CITY OF ALBUQUERQUE

October 12, 2021

Re: Chipotle Mexican Grill
1000 Juan Tabo Blvd NE
Traffic Circulation Layout
Architect's Stamp 09/29/2021 (J22-D012D)

## TRAFFIC CIRCULATION LAYOUT PLAN

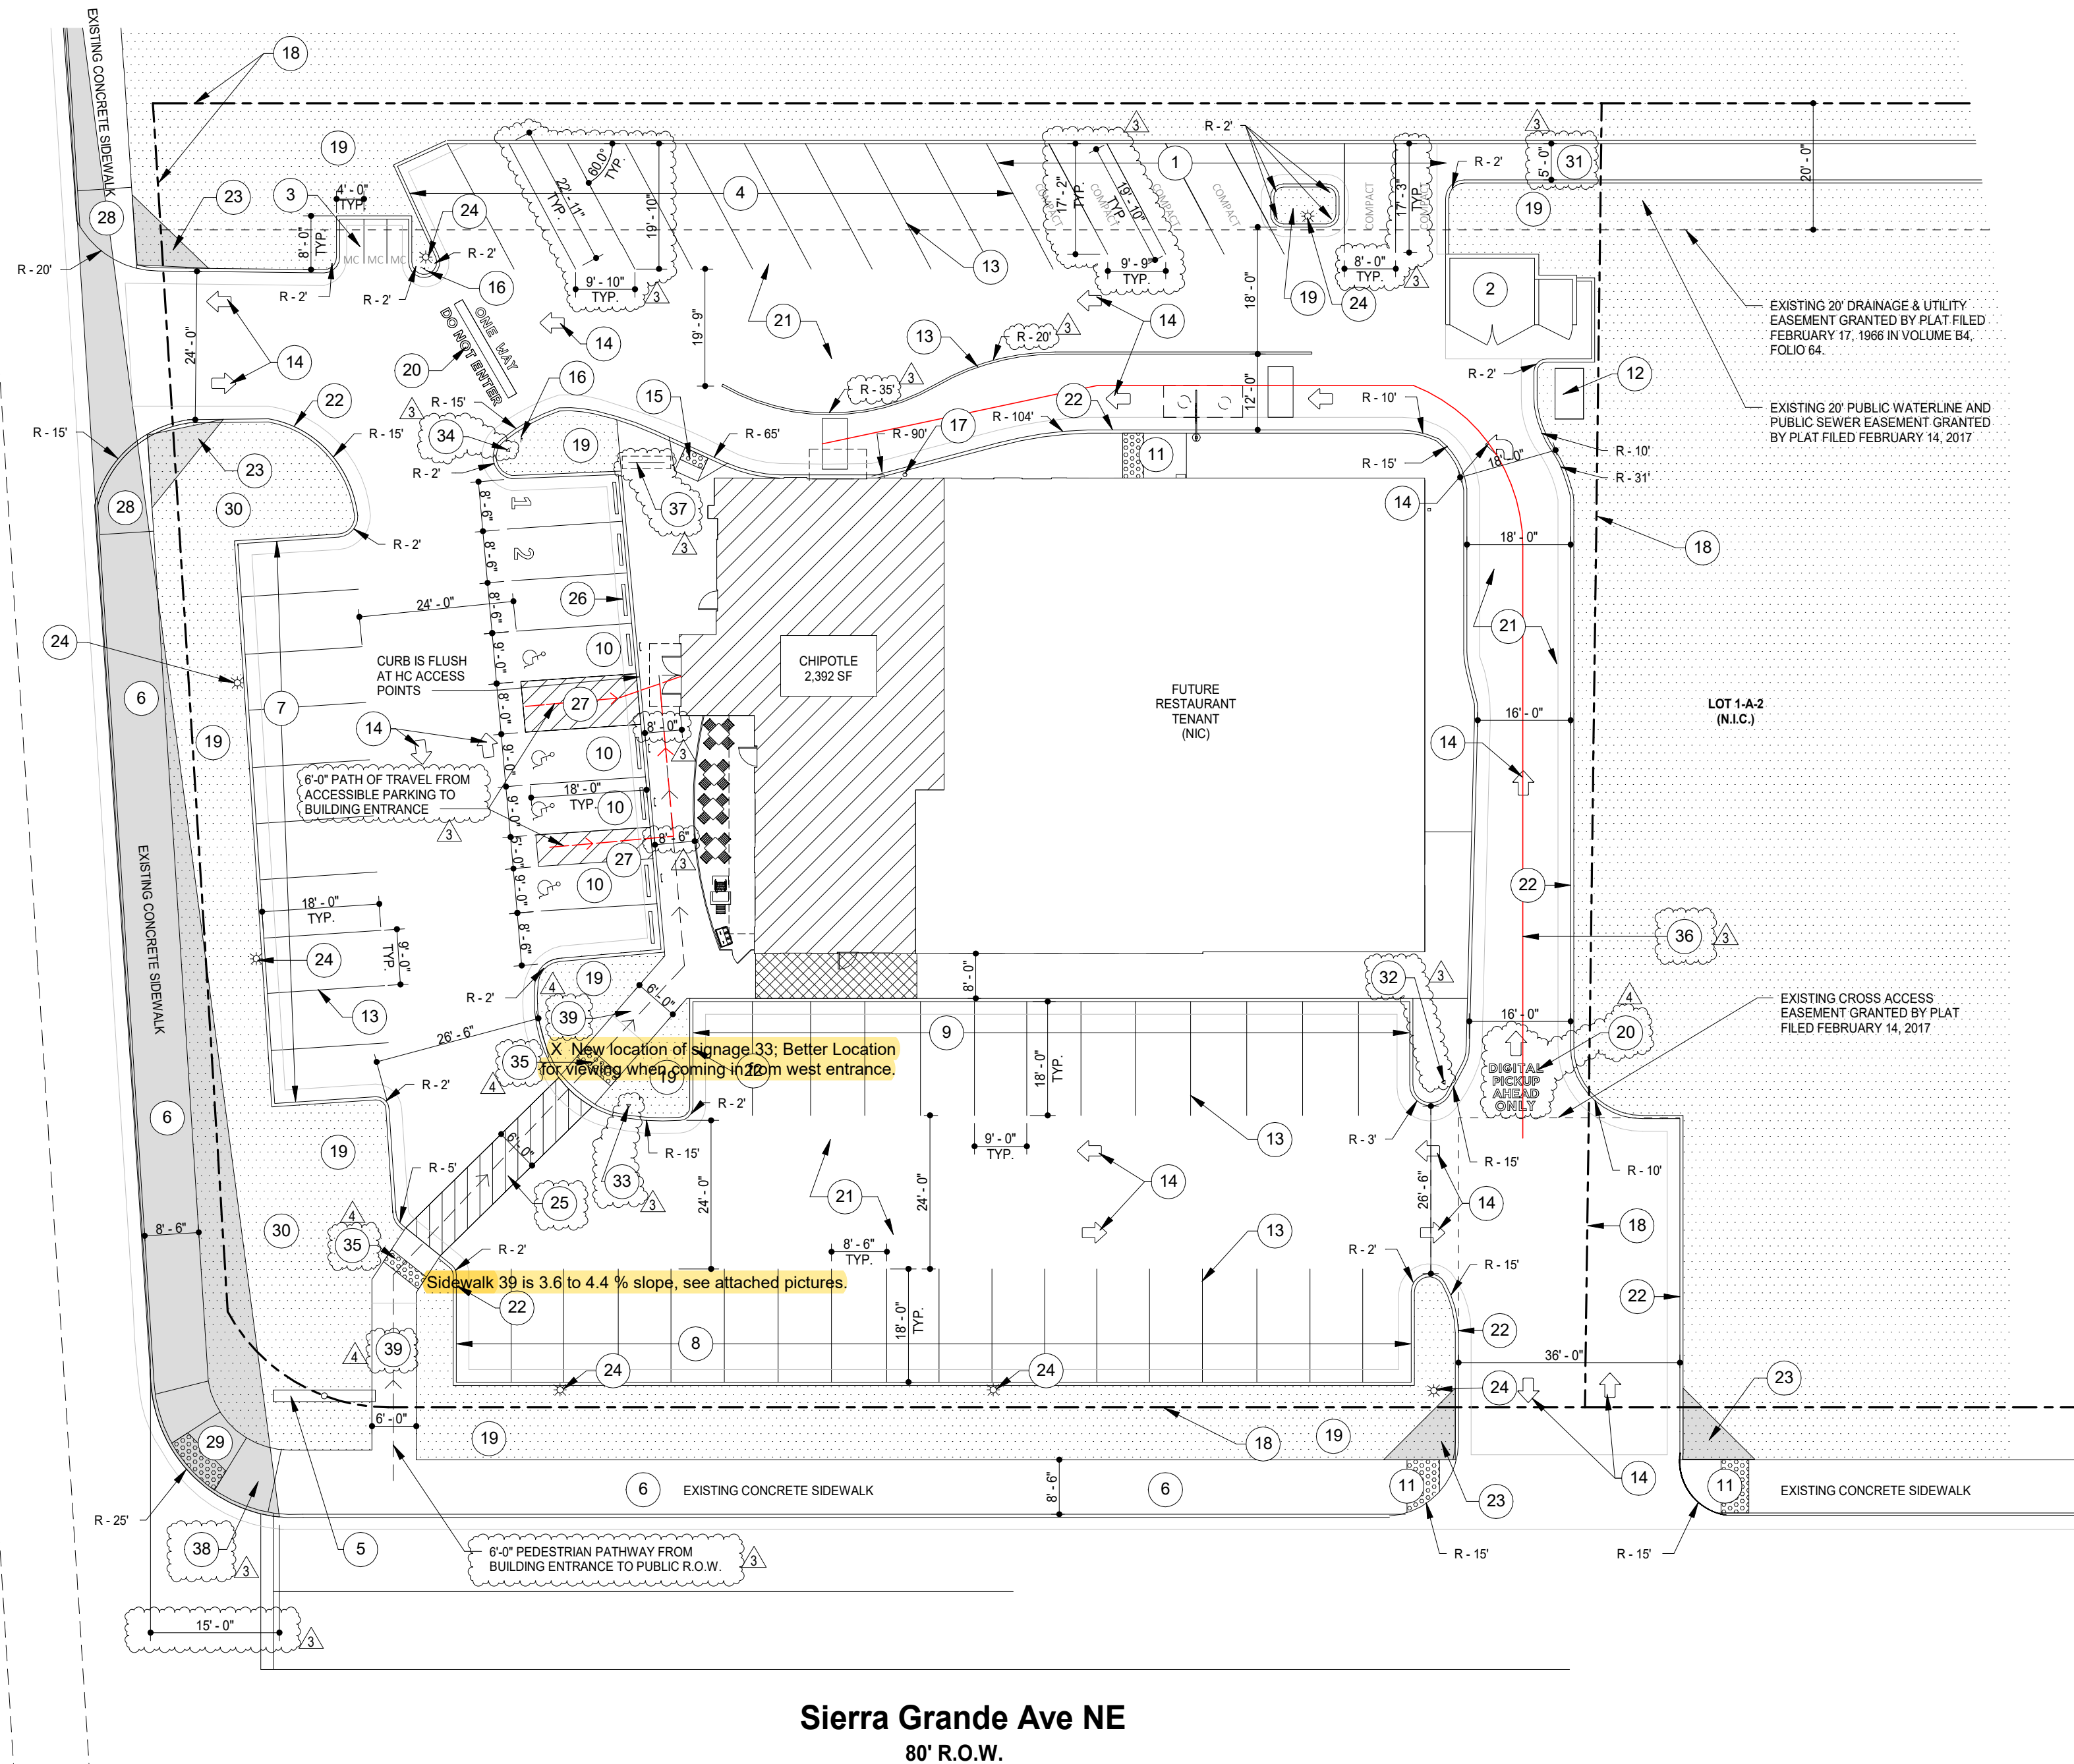
1. **Submit/Provide FD Fire One approval site plan.**
2. **Drive thru lane (Existing):**
 - The order menu board is not shown to determine the total queuing length. **Since the site will be a mobile order pickup option only for diners, you will need to provide as such a advance signing prior to entering the drive thru queue or else you will have problems with vehicles being stuck in queue line that shouldn't be due to error on the drive thru process.**

3. **Exiting Plyon Sign (REVOCABLE PERMIT): An approved Revocable Permit will need to be provided prior to TCL Project approval.**
4. **Keyed note 20: Add the verbiage ONLY to the pavement marking stated as Digital Pickup Ahead ONLY.**

5. **Per DPM, a 6 ft. wide ADA accessible pedestrian pathway is required from the ADA parking stall access aisles to the building entrances:**
 - **The 6 ft Pedestrian pathway from public sidewalk to on site ramp prior to drive aisle is not ADA accessible. The is 6ft pathway will need to be ADA compliant for pedestrians. The longitudinal and cross slopes grades are too steep (2%max.).**

- **The 6ft Pedestrians pathway is not ADA compliant across the 24 ft drive aisle and this needs to be compliant The is 6ft pathway will need to be ADA compliant for pedestrians. The longitudinal and cross slopes grades are too steep (2%max.).**

- **You will need to provide construction notes to modify these steep slope to meet 50:1max (2%) for ADA compliant. Please address these concerns.**
 - **If discussion is needed, please contact me.**
